Application No: FP/224/20/HH
Site Address: 57 Minton Road Felpham PO22 7JX
Description of works: Two storey side and rear extensions to existing dwelling & replacement of existing front loggia.

Thank you for your internet representation made on 9th December 2020 which has been recorded as an objection with the comments as follows:

SITE BLOCK PLAN 1:500

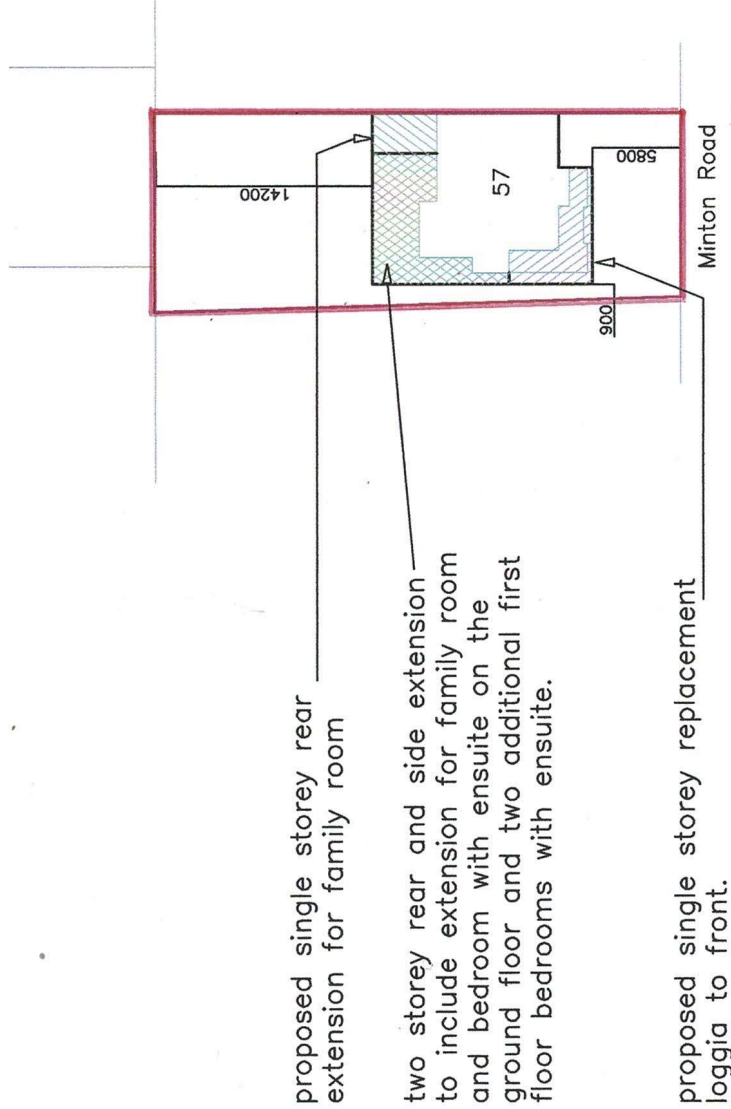
Object. Build is not a metre separation - non-compliant of ADC's policy.
